Issue Specific Hearing 2

Thursday 1 December 2022

Supplementary Agenda Additional Questions

SCHEME KEY PLAN

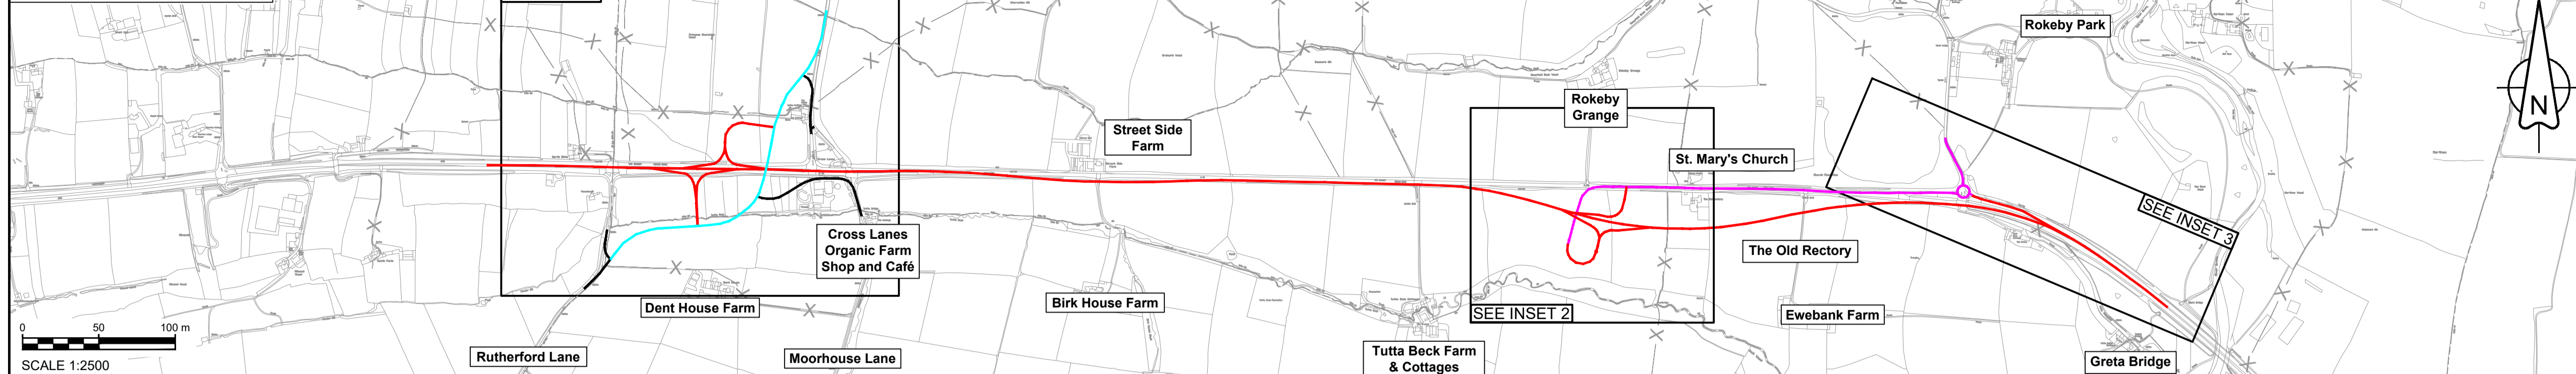
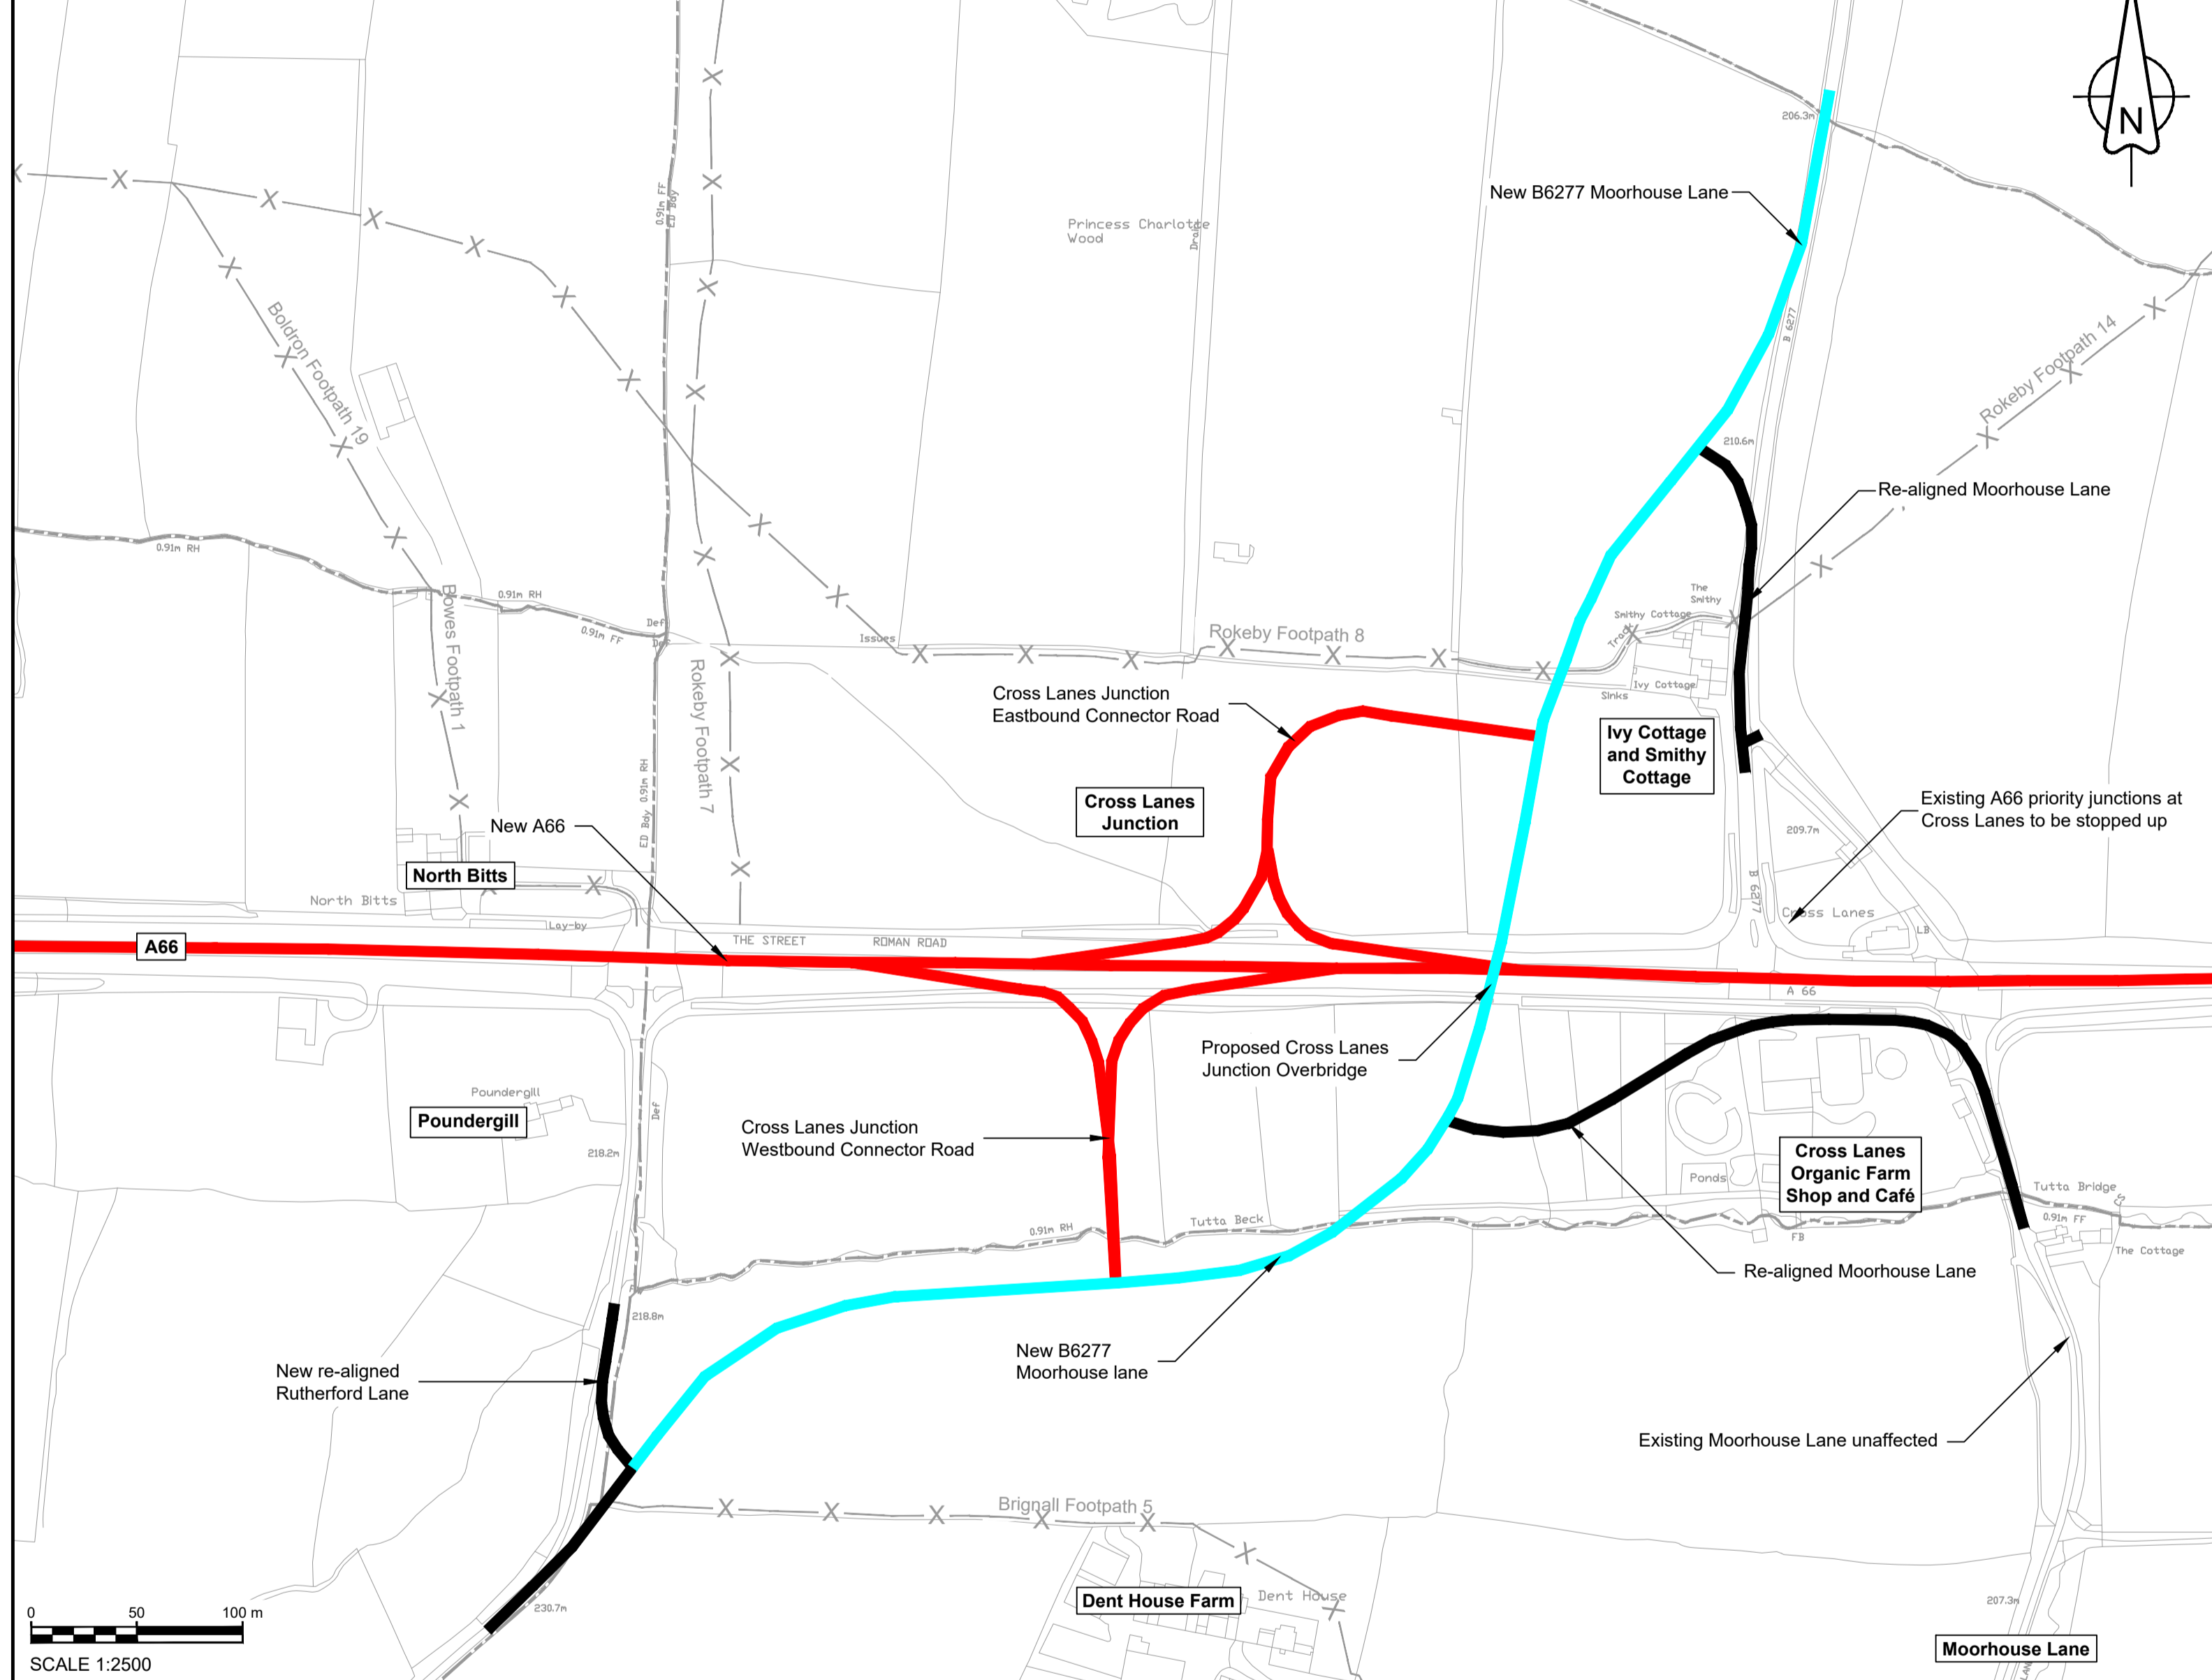
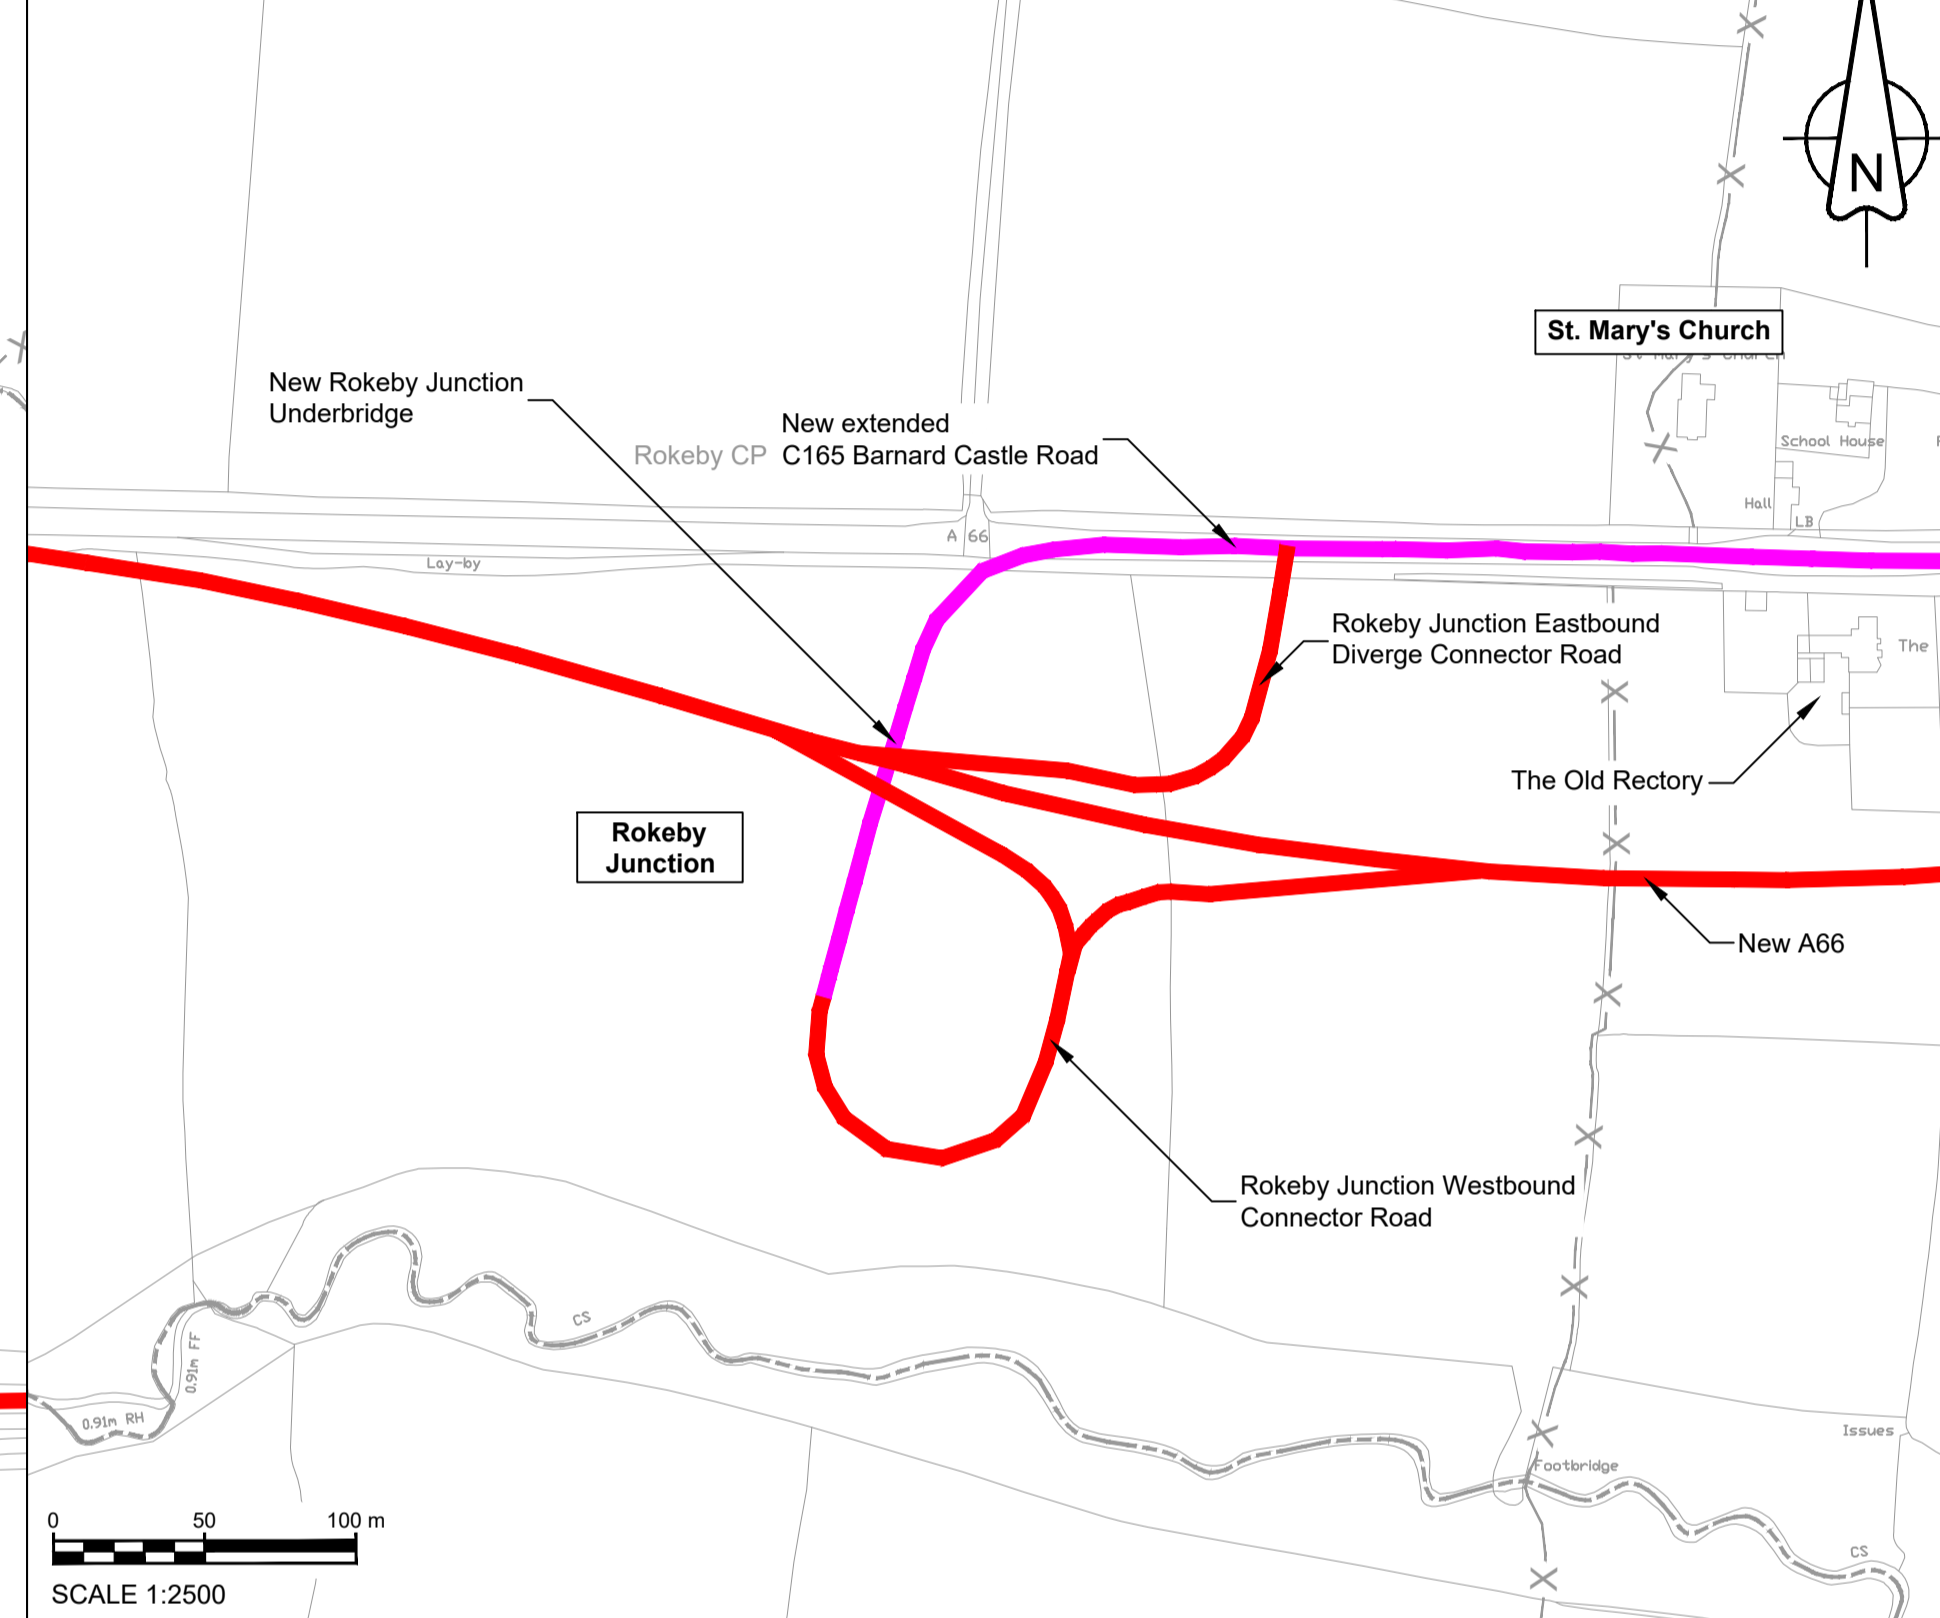
| ISH2.DCO.18 | Schedule 7 | Applicant | Paragraphs 55 and 56 both reference the new B1066. A and B classified road numbers are usually approved by DfT and are usually unique. There is already a B1066 (south of Bury St. Edmonds). Additionally, the use of a number starting B1... is unusual in road classification numbering to the west of the A1 which usually adopts the B6... sector convention. Confirm that this number been approved by DfT |

| ISH2.DCO.19 | | Applicant and Cumbria CC | Paragraph 56 (b) sets out that the B1066 ends at <i>“a point 254 metres west of the junction of Musgrave Lane and Main Street”</i> . Confirm that this is that a suitable point to start a classified road on the unclassified Main Street. Confirm whether it would be more conventional to connect the new B1066 to the existing B6276 on Main Street at its junction with New Road. |
| ISH2.DCO.20 | Schedule 8, Part 4, Revocations and Variations of Existing TROs | Applicant | There is an existing signed no entry restriction for westbound traffic on the extension of Main Street to prevent westbound traffic accessing the existing eastbound off slip of the A66. Confirm whether this would need to be revoked as this is intended to become a two-way B1066. |
